# CITY OF ALBUQUERQUE

**Re: Desert spring Nursery, 135-137 Charleston SE,  
(D-19/D134)  
Approval of Permanent Certificate of Occupancy,  
Engineer's Stamp Dated: 02-23-07  
Engineer's Certification Date: 4-22-09**

**Re: Desert Spring Nursery, 135-137 Charleston SE,  
Certificate of Occupancy – Transportation Development  
Architect's Stamp dated 04-25-07 (K19-D134)  
Certification dated 03-24-09**

GRADING PLAN

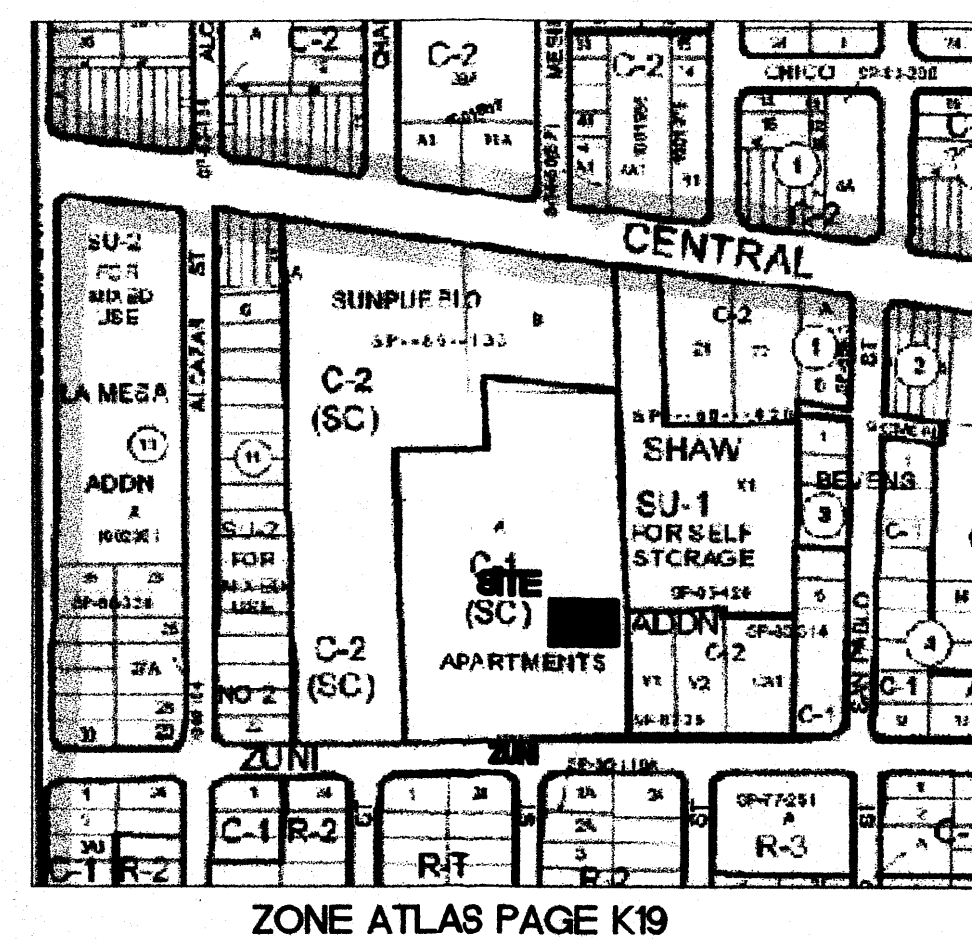
- Your Drainage Management Plan narrative refers to the unit runoff rates (cfs per acre) not the total runoff values. Please revise accordingly. Are there any off-site flows entering the site?
- A cross-lot drainage easement is necessary. Be advised that, given the proposed structure location, a platting action will likely be required by Zoning.

SITE PLAN - NEW, FLOOR PLAN - NEW, DETAILS

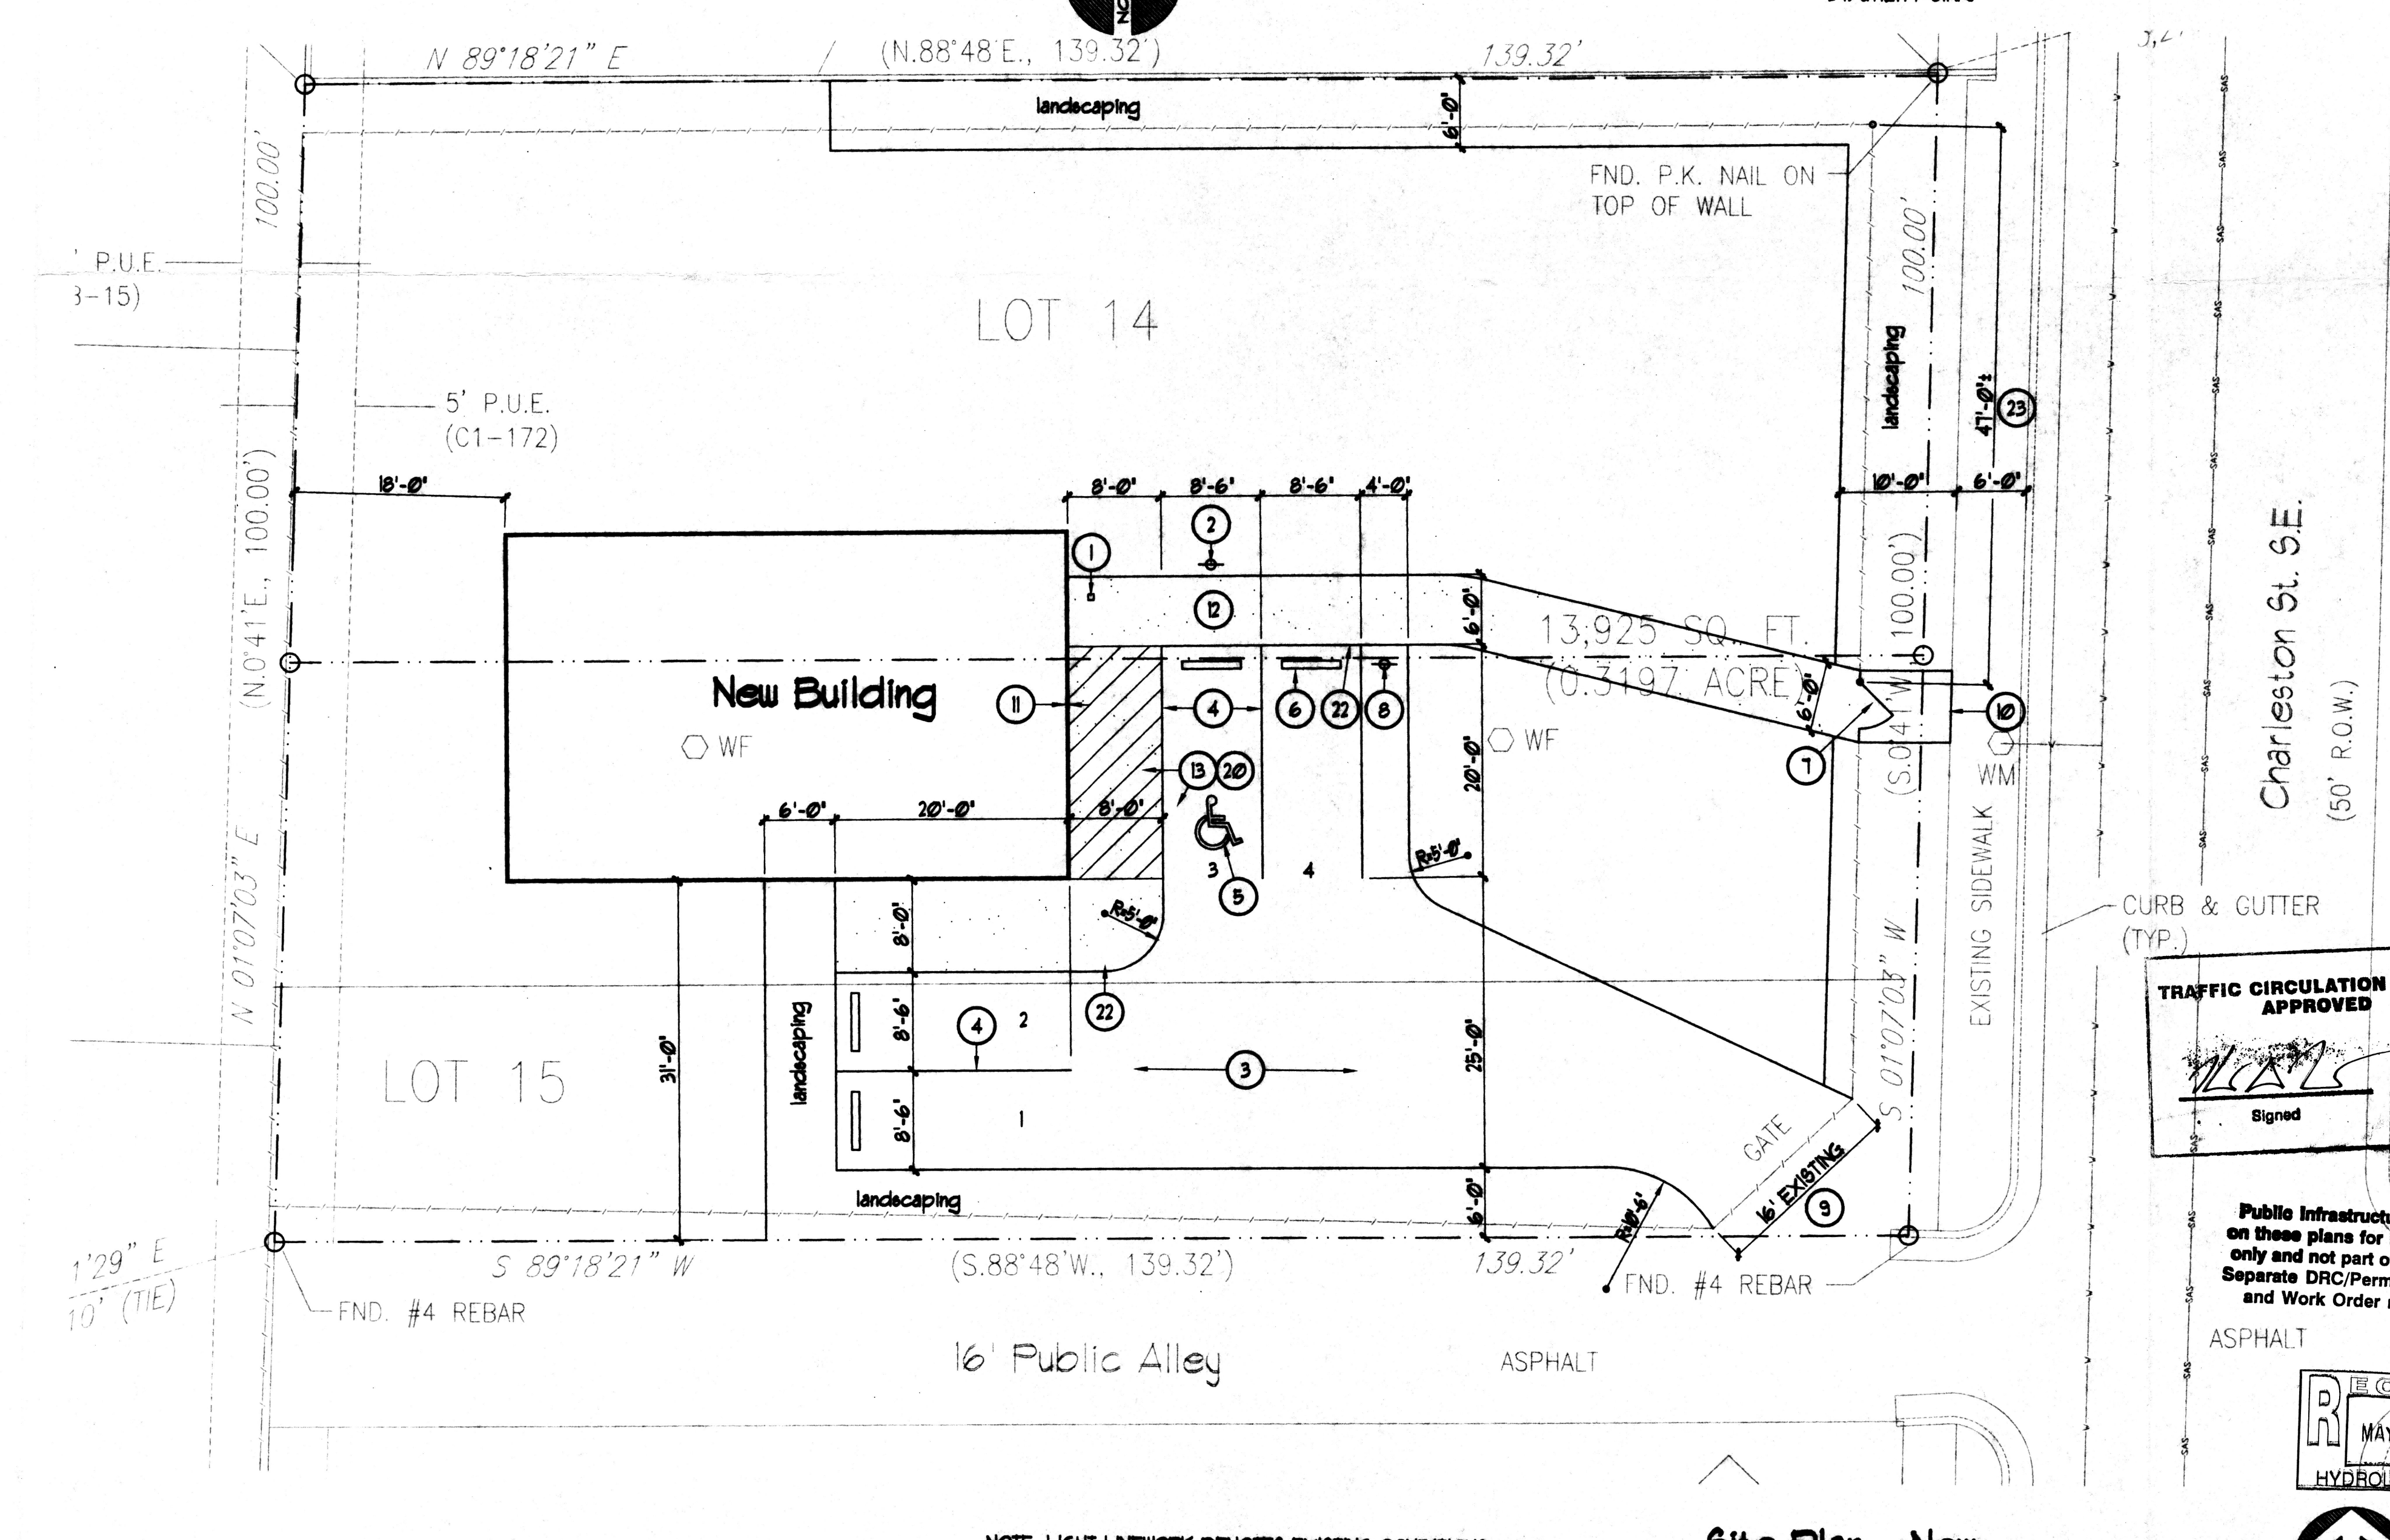
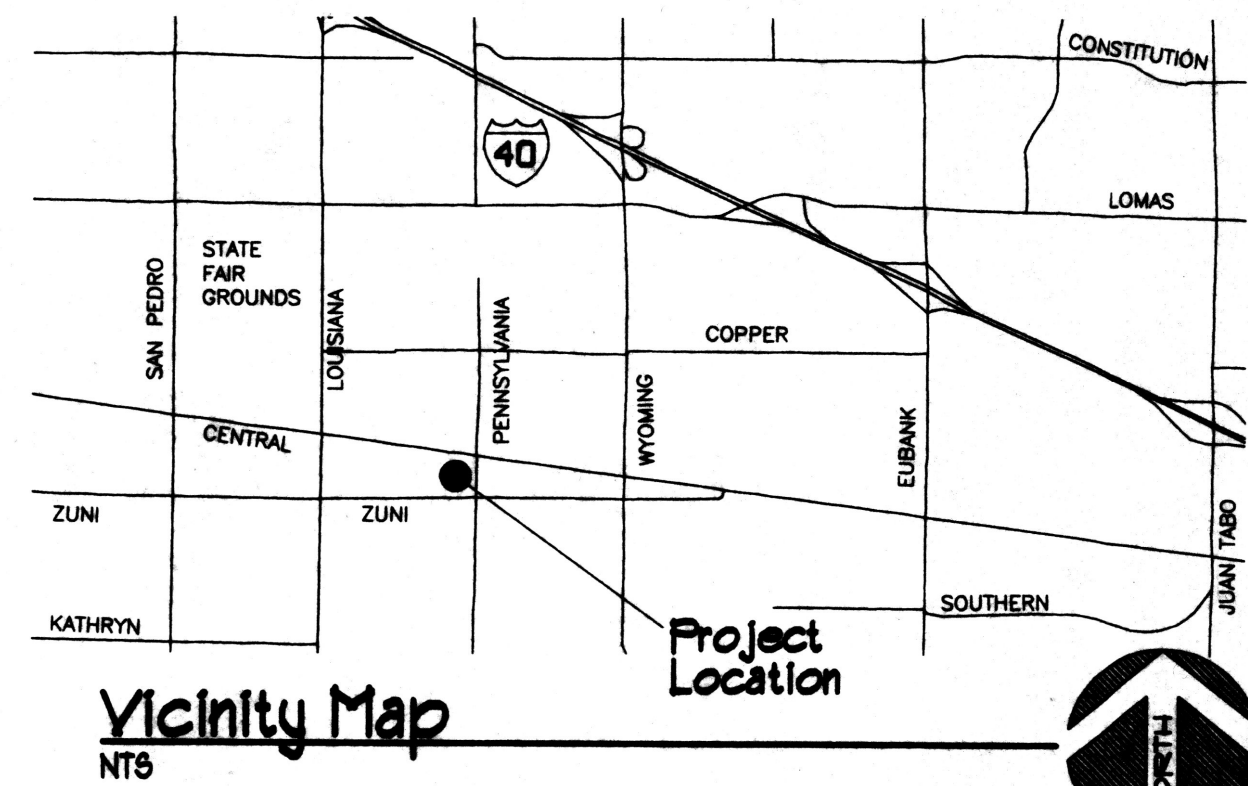
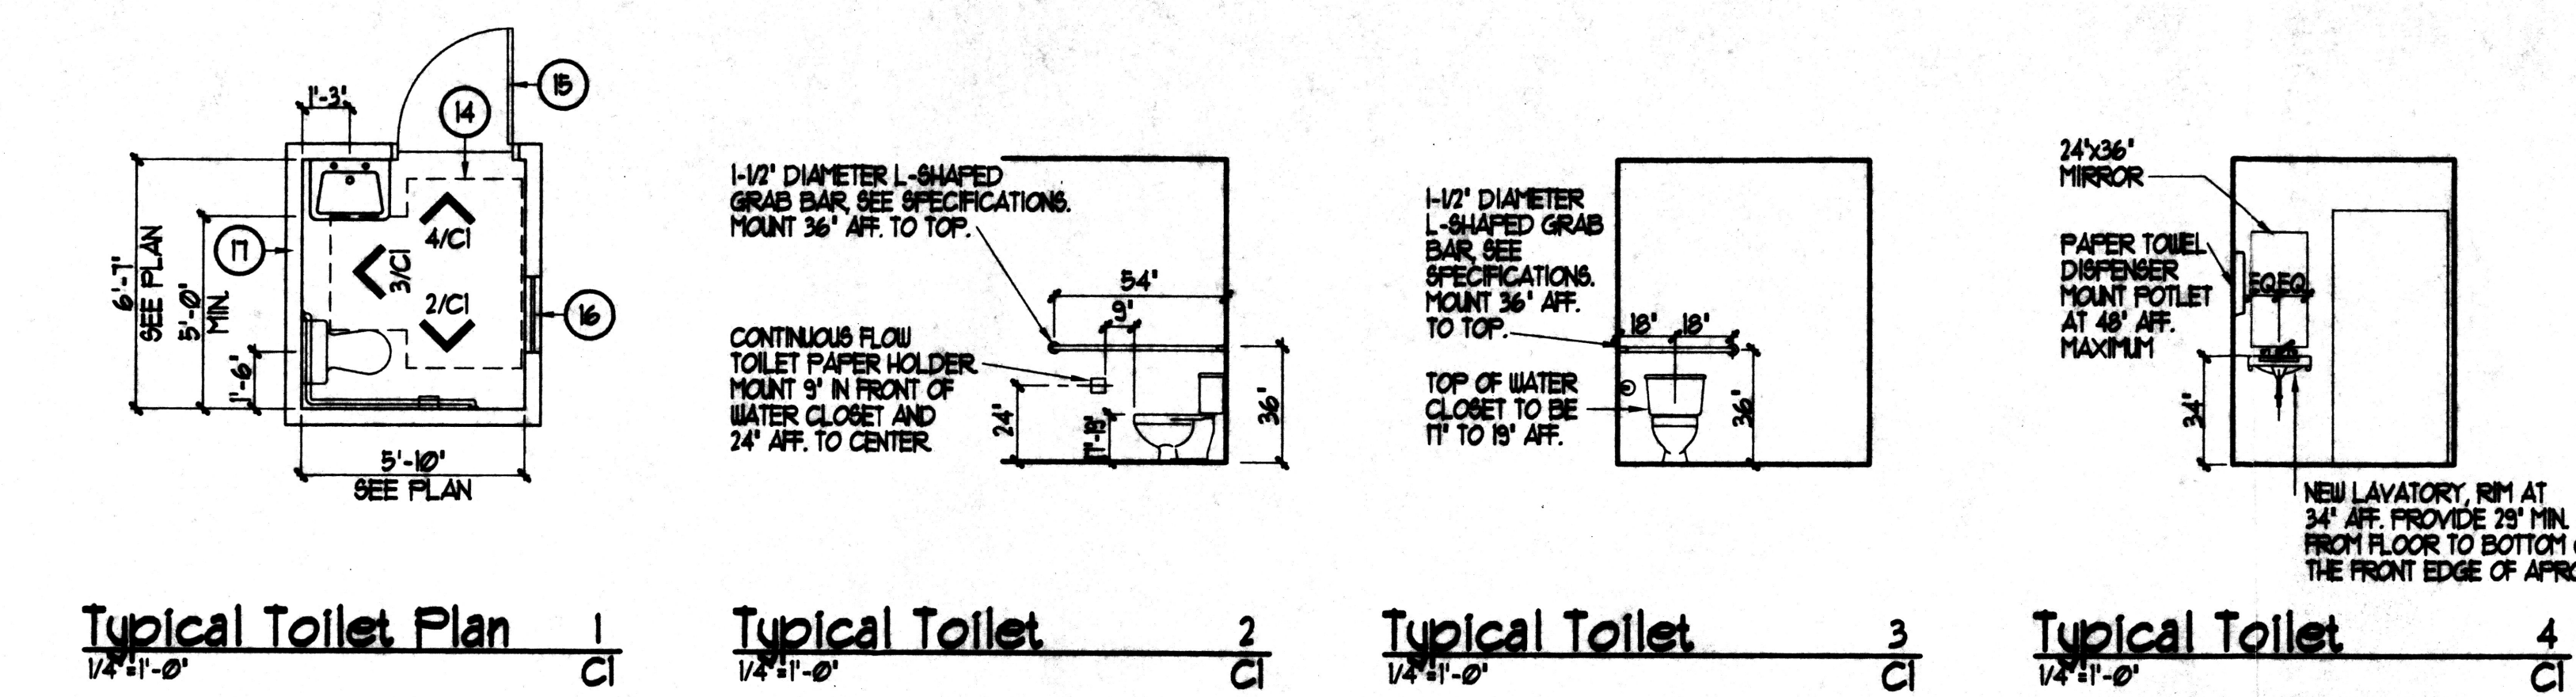
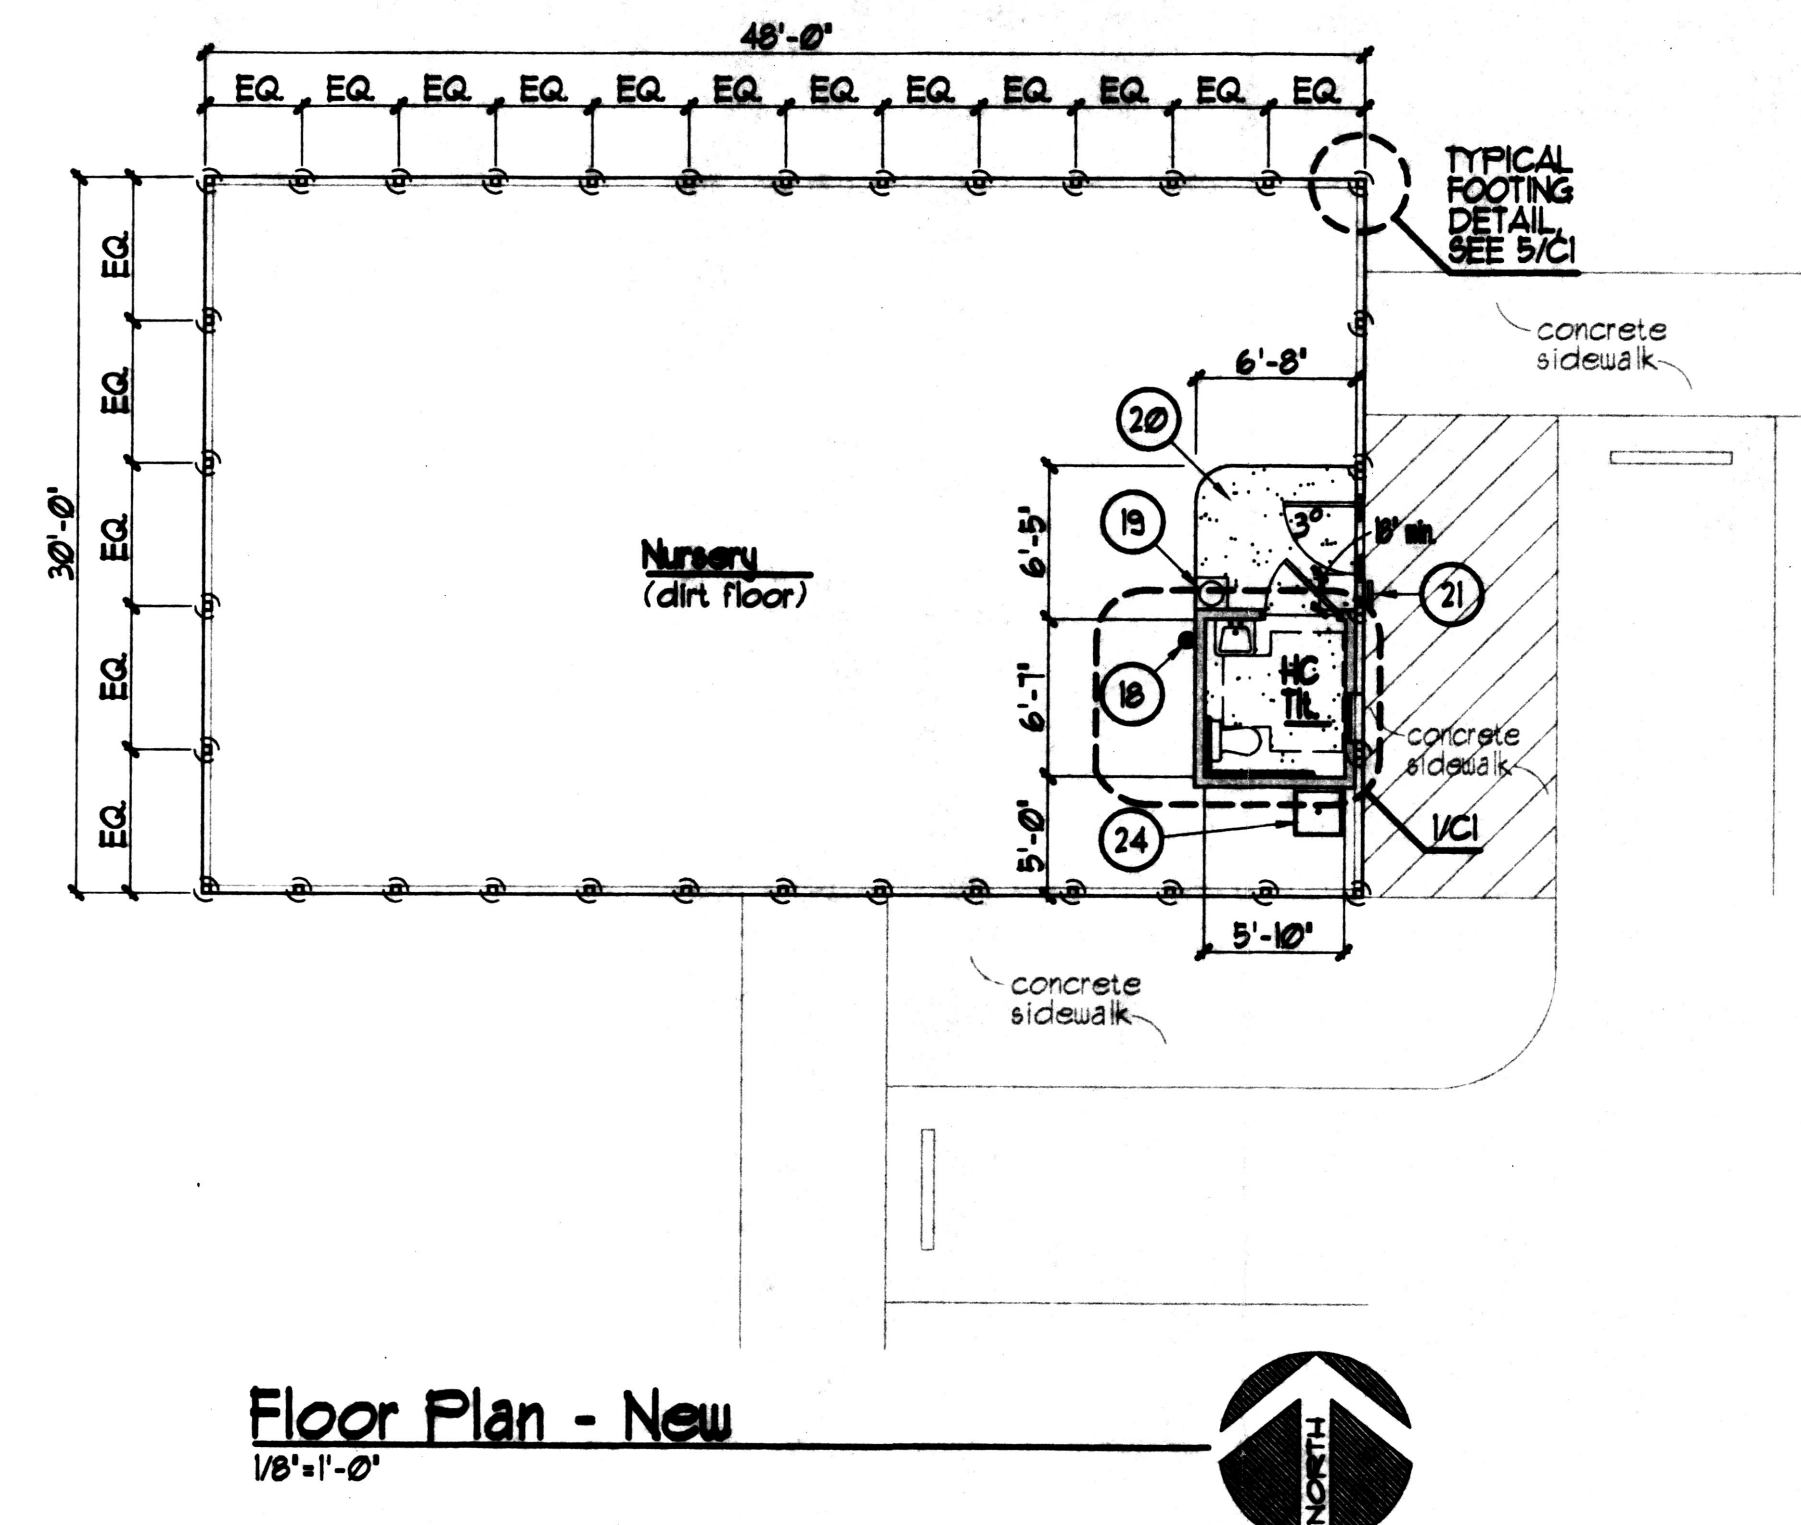
1. Please show a vicinity map.
2. Provide more detail on the entrance. Per your previous discussion with Wilfred Gallegos, the location of the entrance was to be located further to the west off of the alley. In addition, you may need to move the entrance gate further back from the entrance. Please provide the queuing distance for this entrance.

3. Will the Passage Gate (see keyed note 7) be ADA compliant?
4. Is the proposed 6' Pedestrian Path and the 8' pathway around the building flush with the parking lot pavement or raised?

5. Clarify existing versus proposed conditions.
6. Define the width of the driveway. ~ 24' Required
7. What is the current status of the alley? Is it paved? Is there curb and gutter? Will the driveway interfere with the curb returns at Charleston and the Public Alley?

8. Are there existing ADA compliant wheelchair ramps at the intersection of the Public Alley and Charleston? If not, this will need to be remedied at this time

9. What is the width of the sidewalk along Charleston?
10. Include a copy of refuse approval with the next submittal. *ok'd by WG*
11. List radii for all curves shown.

12. The handicapped space must include an 8-foot wide van access aisle in order to be a "van accessible" space. This space should be located to the right of the space. *WG ok'd to the left of space*

*Requirement waived by WG 4-24-07*
